Len Unsworth
478 Wilson Street
Darlington, NSW 2008
6 November 2013

***Modification Request for the University of Sydney Abercrombie Precinct
Redevelopment: Application Number: MP07_0158 MOD 3***

Ground Floor Plan
1:200@A1
11.10.13
4001_DA02-D

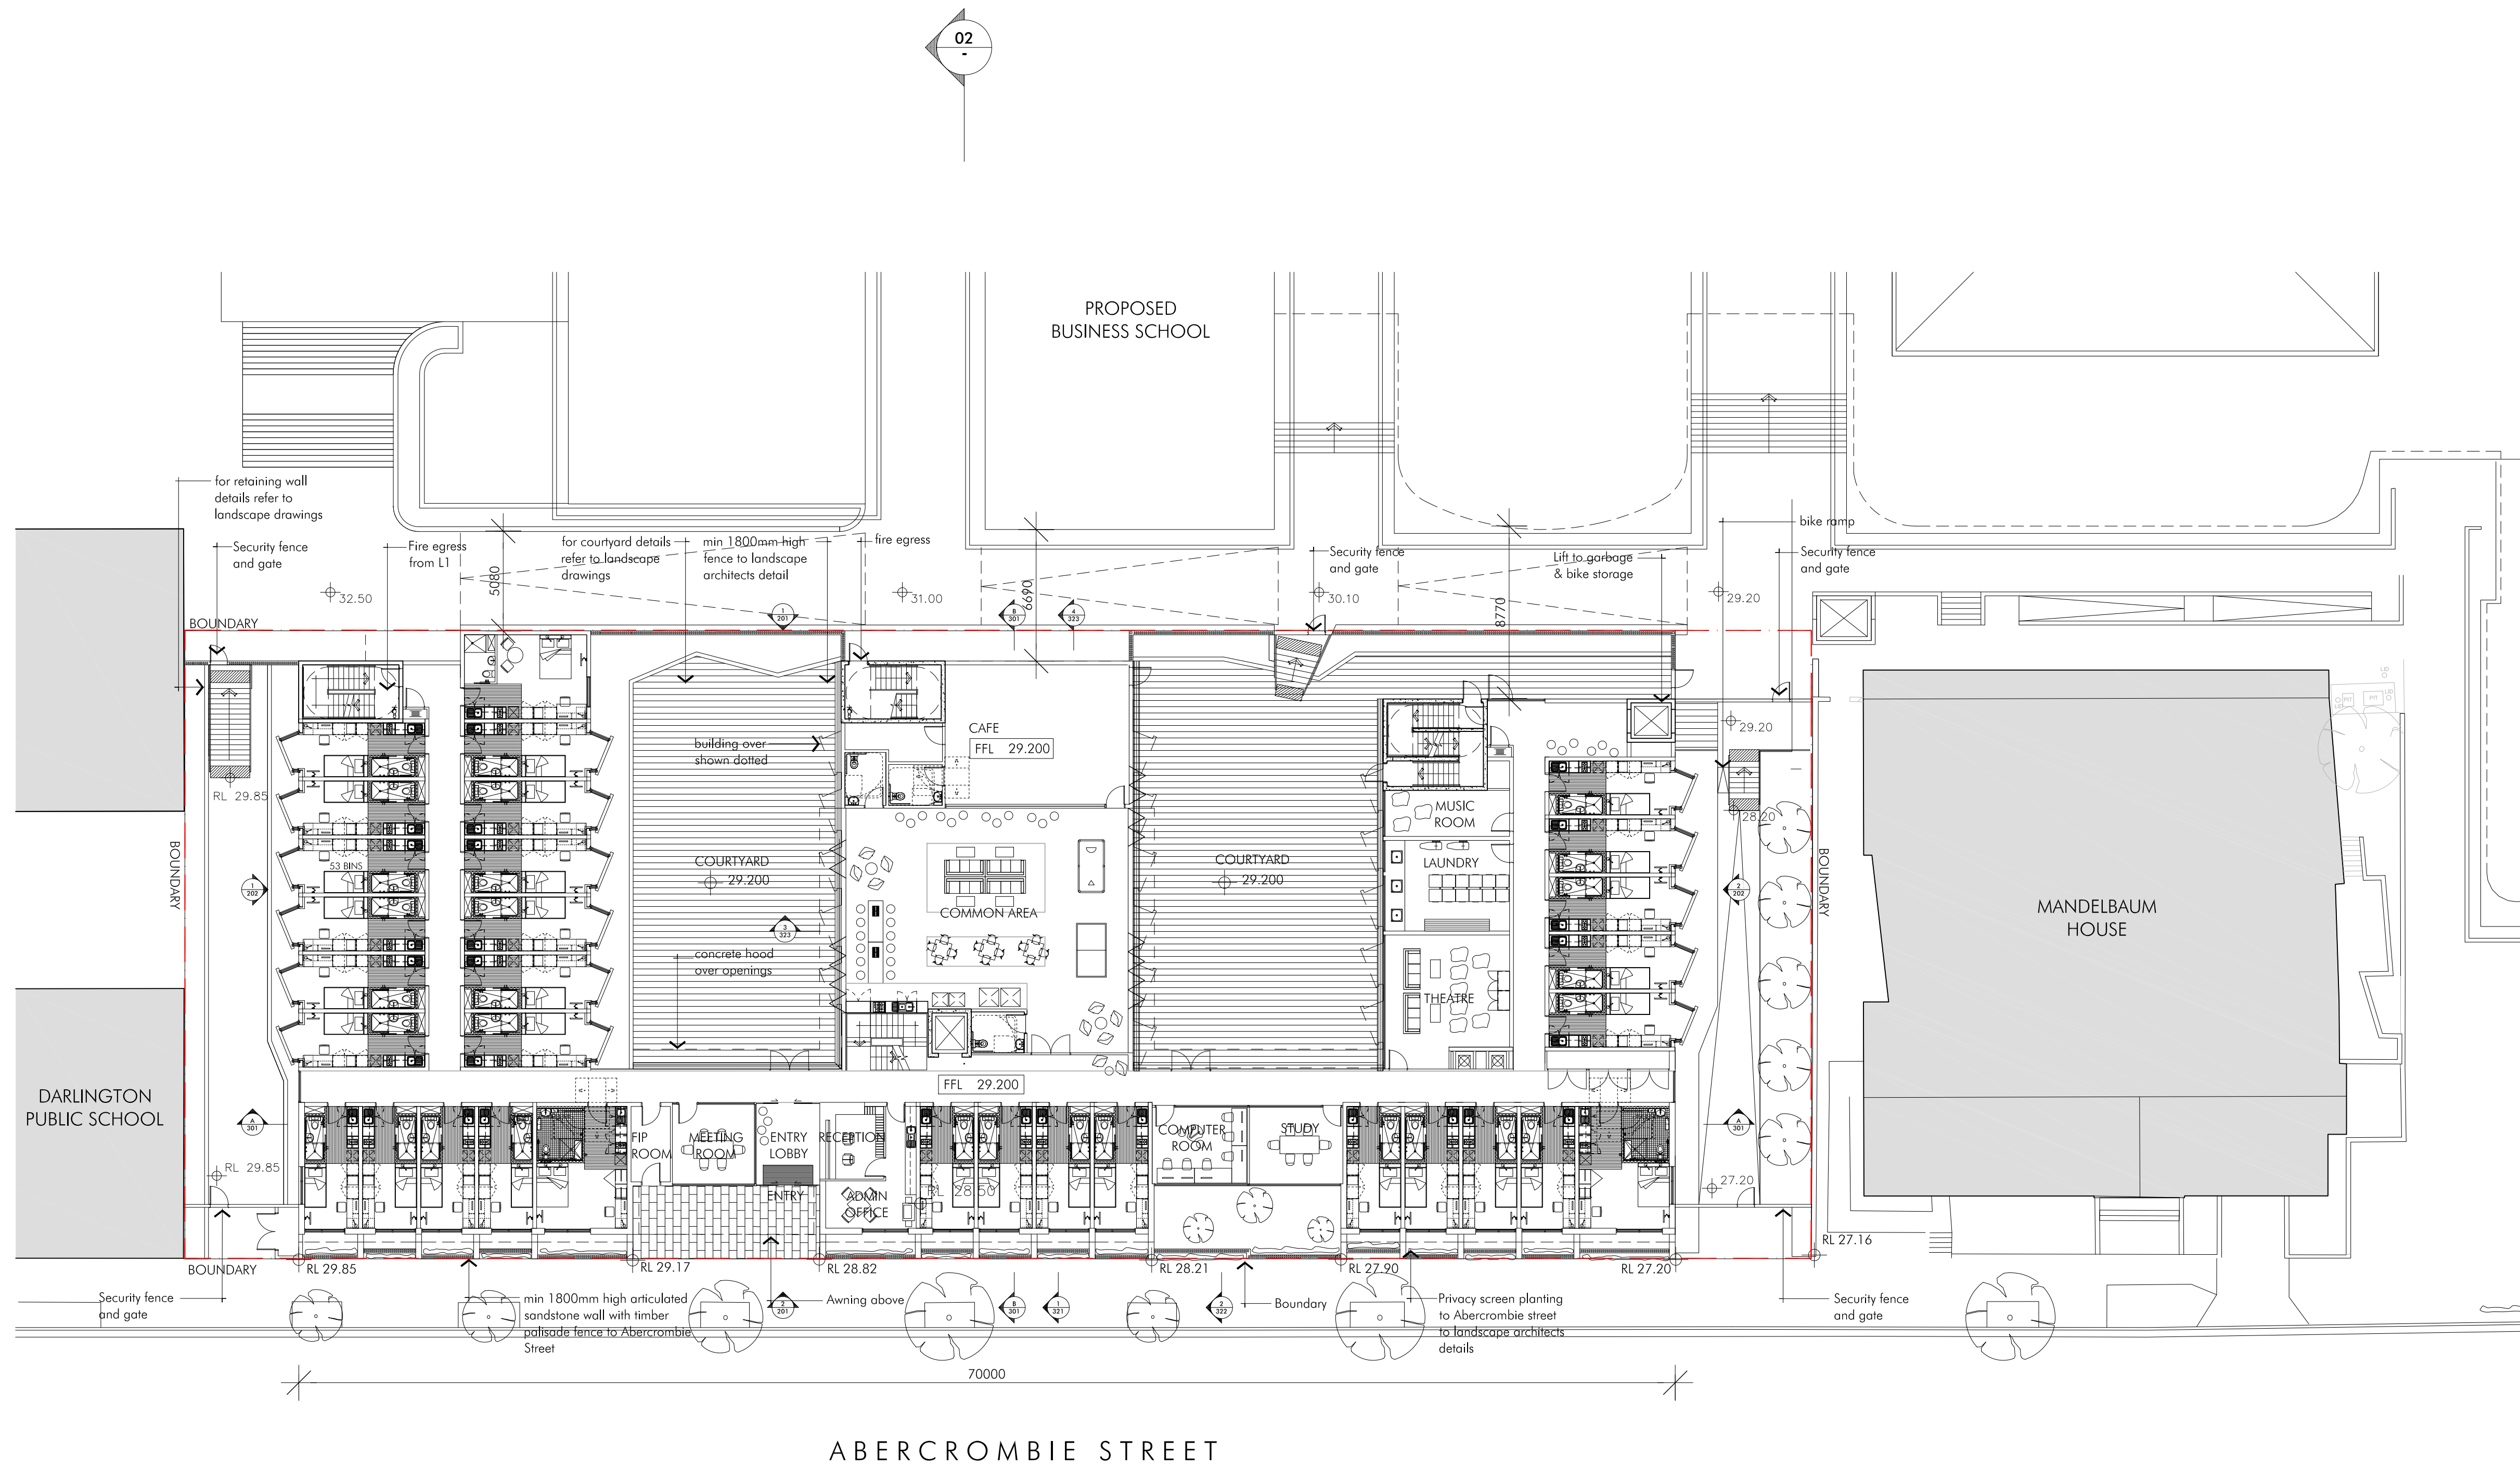
- The front of the Student Accommodation building should be built 2 metres back from the Abercrombie Street boundary. It should be set back from this boundary so that it is in line with Mandelbaum House as it was originally planned and presented to the community. The footprint of the buildings currently on the site, The Shepherd Centre and Boundary Lane Children's Centre, were built approximately 2 metres back from the Abercrombie Street boundary and align with Mandelbaum house. Therefore, the front footprint of the proposed Student Accommodation building should be the same as those buildings occupying the site at present and not be built up to the Abercrombie street boundary.

- The facade of the proposed Student Accommodation building does not reflect the heritage appearance of the Victorian terraces on Abercrombie Street as Mandelbaum House does. Therefore, it should be set back to allow for extensive vegetation and trees to be planted in front of the building on Abercrombie Street to help preserve the heritage streetscape and improve both the aesthetics and the environment of the street.
